BOGNOR NORTHERN RELIEF ROAD, PHASE 1

“PROPOSED PLAYING FIELD ACCESS” (Version 2.0)

Road Safety Audit Combined Stage 1 & Stage 2 – Detailed Design

Designers’ Response- Glenn Tregillis May 2015

PROJECT:	BOGNOR NORTHERN RELIEF ROAD
TITLE:	SPORTS PITCH ACCESS GENERAL ARRANGEMENT

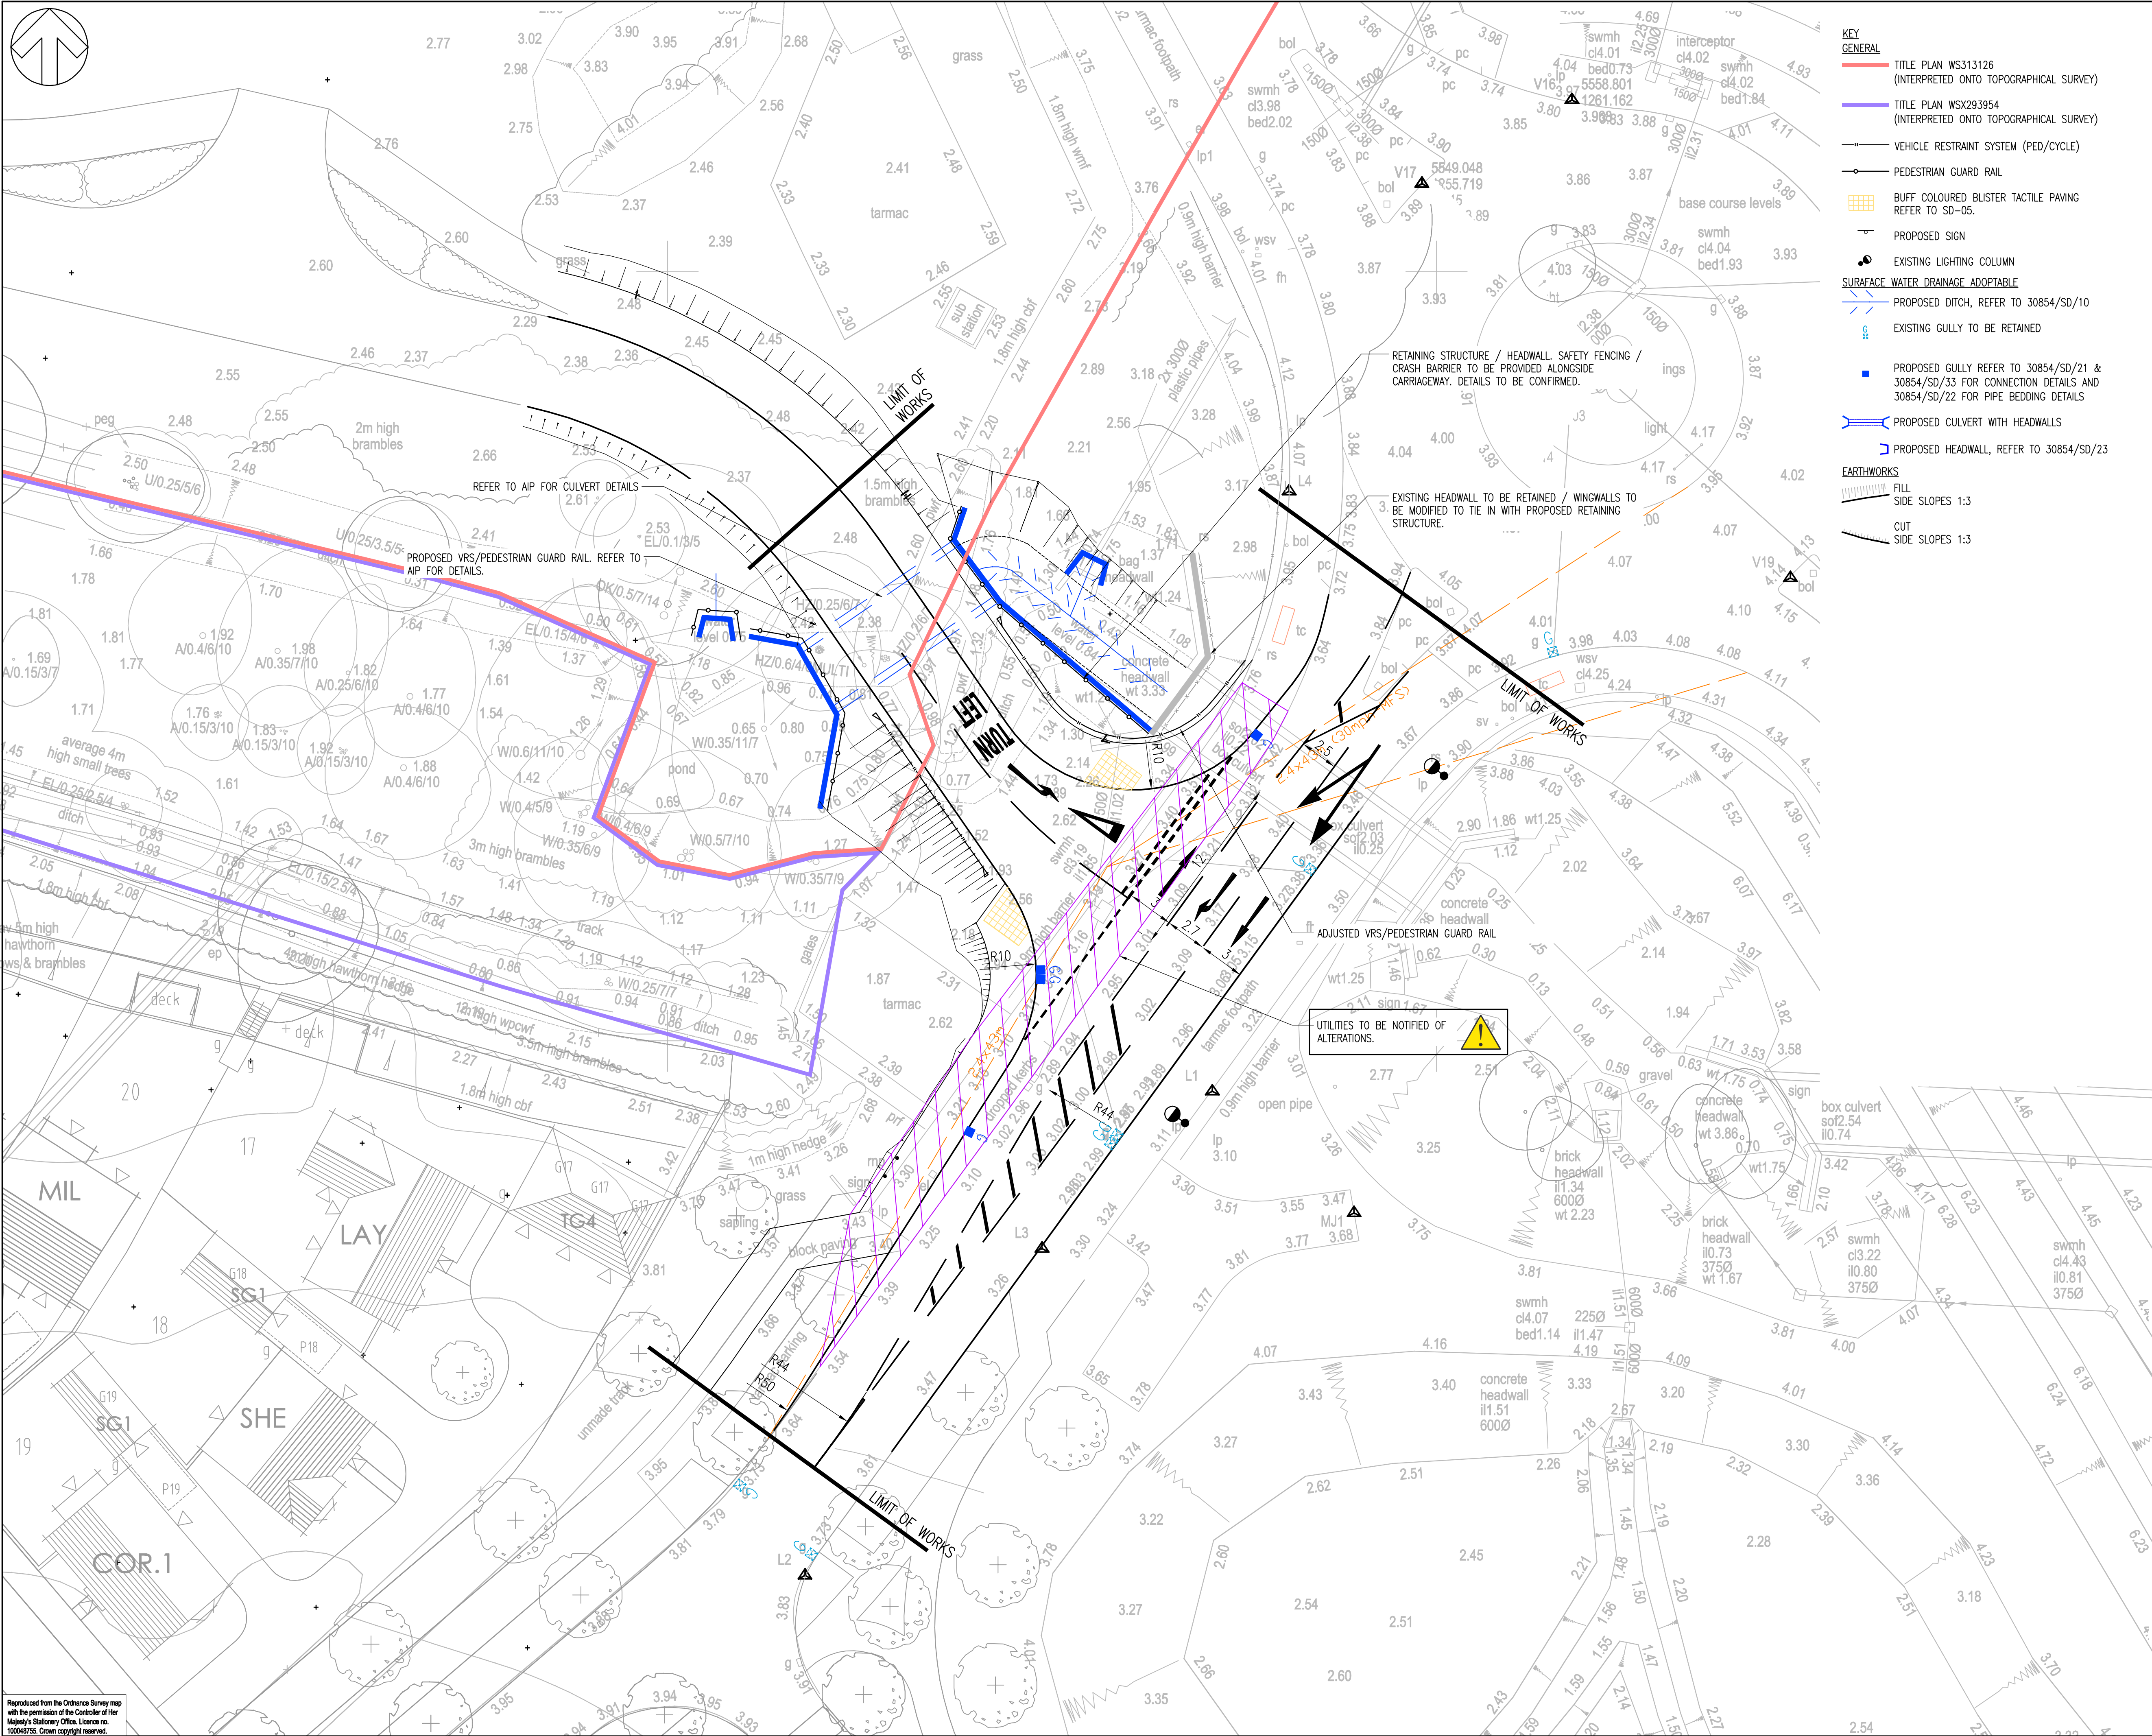
Location: Playing Field Access Road and the junction with the Southern Arm of the Stanover Lane Roundabout.

Summary: Risk of rear end shunt between vehicles exiting the roundabout.

At the existing westbound carriageway of the Northern Relief Road approaching the Stanover Lane Roundabout, the proposed Playing Field Access within the Southern Arm will be hidden from view of westbound drivers by the combination of current Vehicle Restraint Barriers on the inner radius of the horizontal exit curvature and the adverse vertical down gradient of the carriageway into the housing Development, thus creating lack of sufficient clear forward visibility for westbound drivers turning left towards the location of the proposed access to the Playing Fields and Potential School Premises. These conditions are also likely to be exacerbated by the future growth of the planting currently located behind the VR barriers.

Owing to these conditions and the close proximity of the proposed new access on the existing carriageway, if/whenever also combined with potential fast speeds at which some vehicles may be exiting the roundabout (40mph speed limit on the roundabout), some drivers when turning left on the clear sweeping radius into the 30mph section of Development Access Road may fail to slow sufficiently to perceive the risk of a leading vehicle suddenly braking in order to turn right into the Playing Field Access Road or even see a stationary vehicle waiting to turn right. Consequently, there appears a high risk of rear end collisions between such vehicles.

RECOMMENDATION

The proposed access arrangements should be revisited with a view to re-assessing the potential traffic flows at the junction and of sufficiently widening the carriageway locally to provide a segregated area at the centre of carriageway for right turning vehicle to move into and potentially wait for suitable gap if required to do so, whilst the current planting at the rear of the Vehicle Restraint System on the inner radius curvature should be removed.

Location: Proposed Playing Field Access, at the junction with the Southern Arm of the Stanover Lane Roundabout and at the roundabout splitter island.

Summary: Risk of head-on or side-swipe collisions between turning vehicles and risk of large vehicle collision with the splitter island.

The proposed access will be constructed immediately south of the existing roundabout and its splitter island, where currently there is no provision of waiting space for vehicles to wait prior to turning right into the access. Furthermore, the swept path diagram of the single deck bus is shown overrunning the offside exit lane from the roundabout, where collision with vehicles leaving the roundabout may occur and also appears to overrun the splitter island and risks kerb impact.

The proposed access position should be revisited with a view to shifting the access bellmouth further southwards and widening the carriageway of the Southern Arm of Stanover Lane sufficiently to provide space for a short right turn lane for access to the Playing Fields and Potential School Premises.

The proposed access arrangements have be revisited with the inclusion of right hand ghost island with adequate storage for a bus.

Vehicle Restraint System shall be altered to provide for the access.

The proposed access arrangements have be revisited with the inclusion of right hand ghost island with adequate storage for a bus.

| ARCHITECT: | |
|------------|--|
| TITLE: | SPORTS PITCH ACCESS

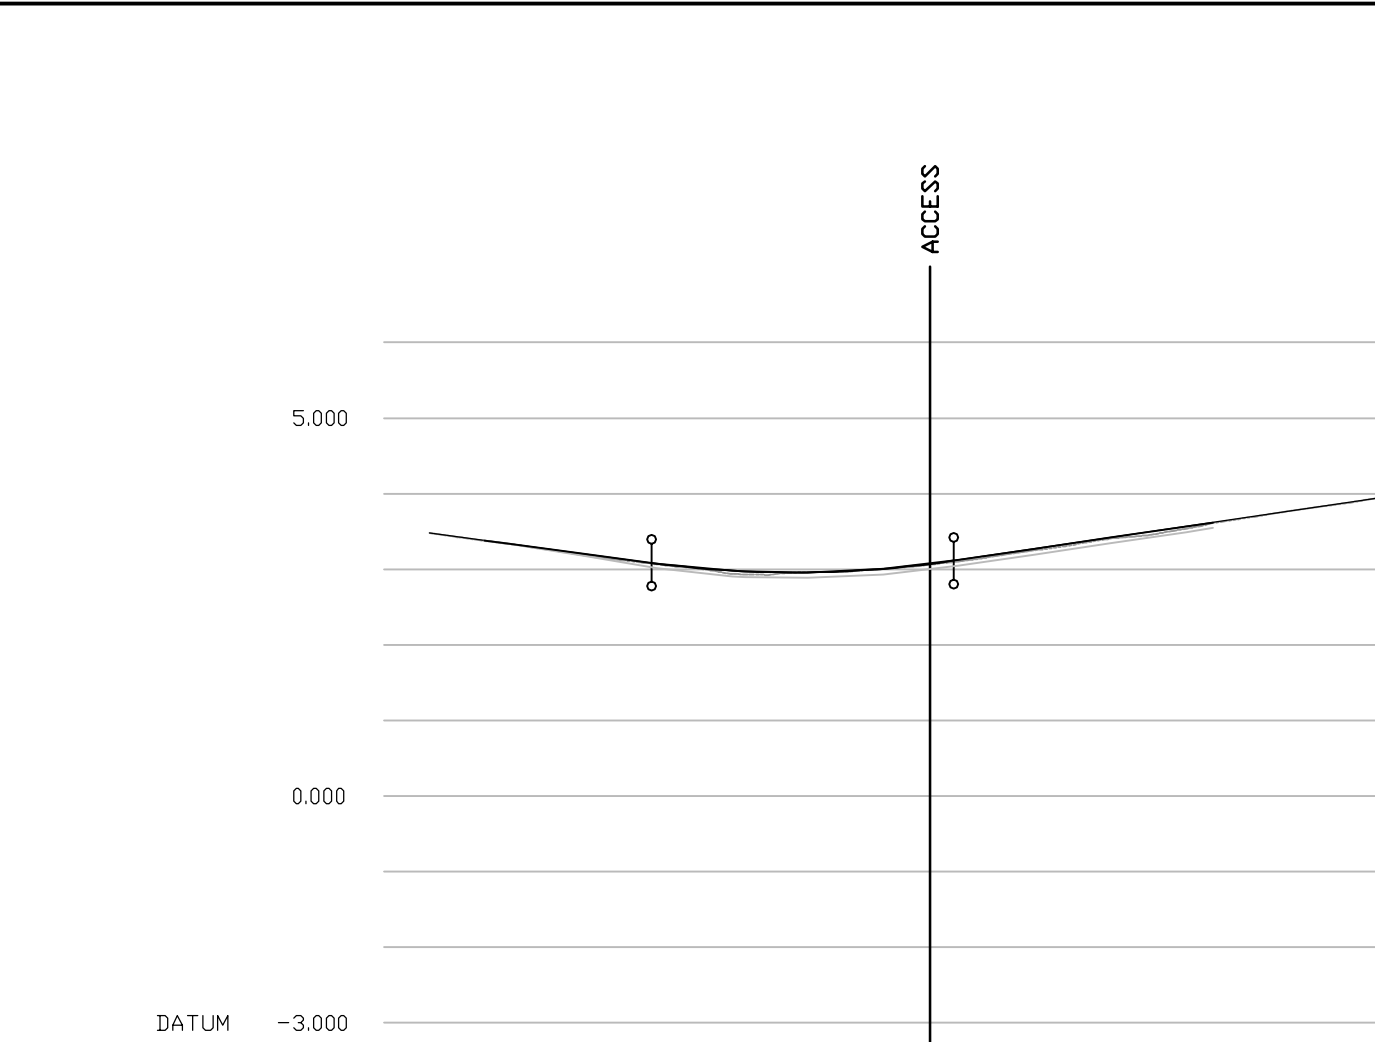
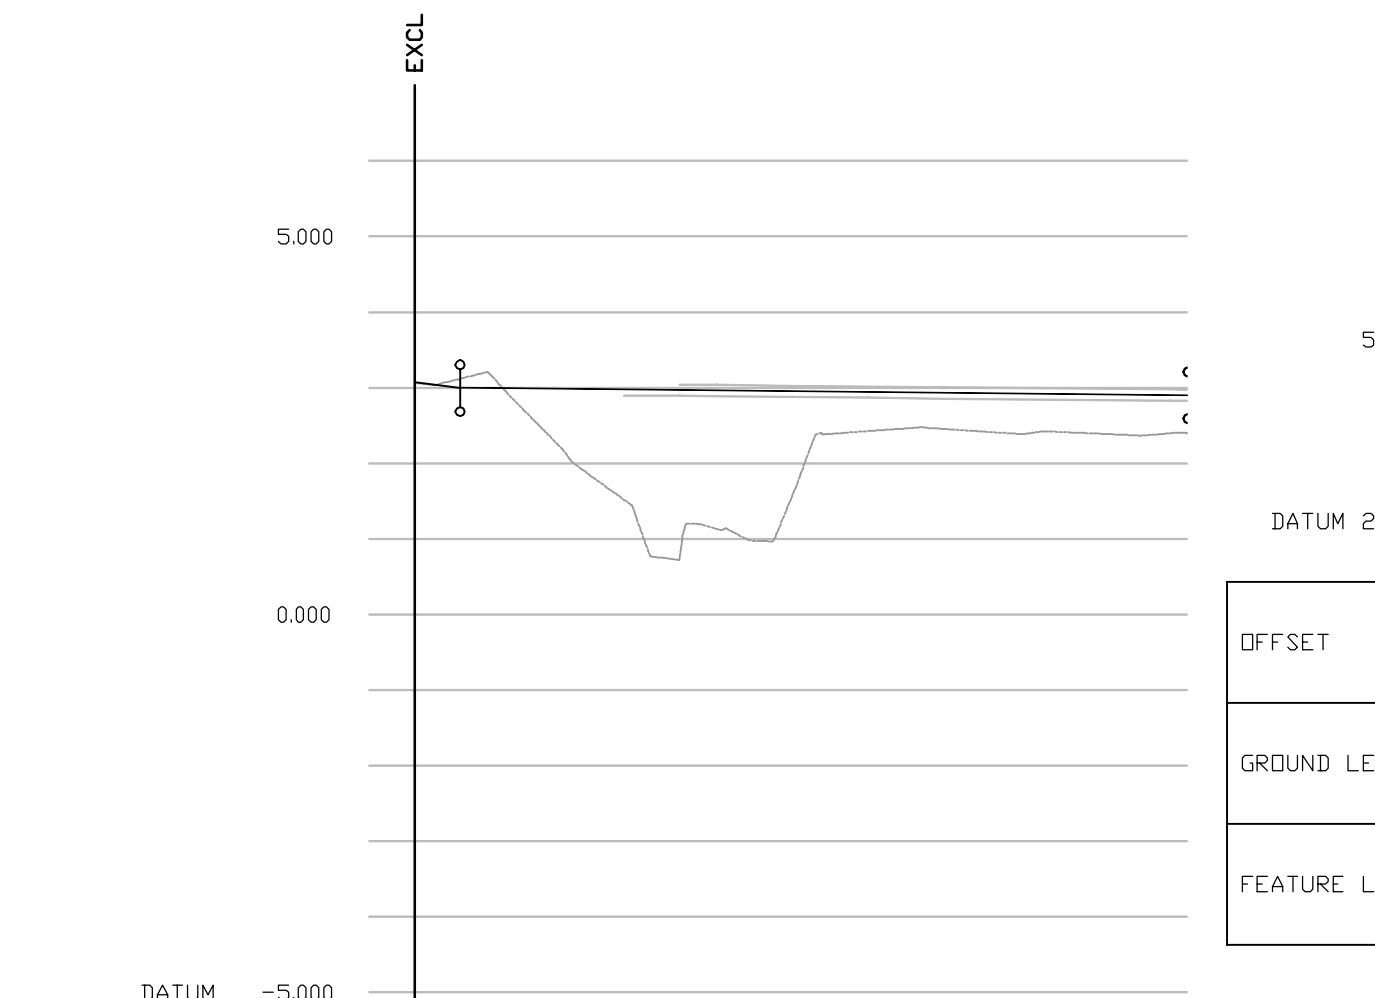
Whilst it appears the new road is to be constructed on an embankment and may also be sloping towards the existing carriageway, the adjacent field access steeply slopes downwards to the adjacent land across which the Playing Field Access Road will cross. Consequently, it is not clear whether there may be risk that vehicles waiting to join the carriageway may roll forward risking conflict with close passing traffic or rolling back onto following waiting vehicles.

The proposed junction may need to be checked to ensure that an almost level area of carriageway should be provided for a minimum distance of 12m or more from the Give Way line in order to allow for buses to stop and wait, and either prevent errant movements or very slow acceleration from stationary positions.

The proposed access arrangements have been revisited with the inclusion of a level platform at the bellmouth.
